**Woolworths Warehouse and Customer Fulfilment Centre, Marrickville (SSD-10468)
Response to Submissions**

Department's Comments

Figure 35 Proposed Truck Routes

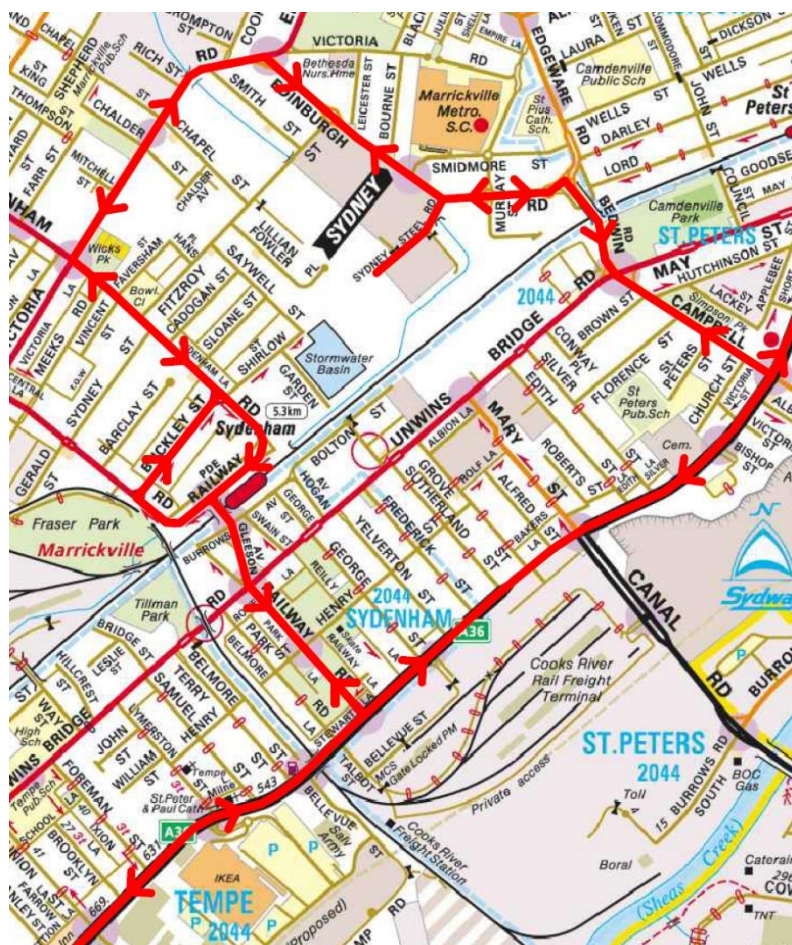
1. The Department notes a number of submissions received from the public have raised concerns regarding heavy vehicles accessing/leaving the site via the north-western section of Edinburgh Road.

Please consider restricting truck movements from turning left out of Sydney Steel Road onto Edinburgh Road to avoid impacting upon the residential area to the north-west. Such a restriction could be proposed through the implementation of a Driver Code of Conduct during construction and operation.
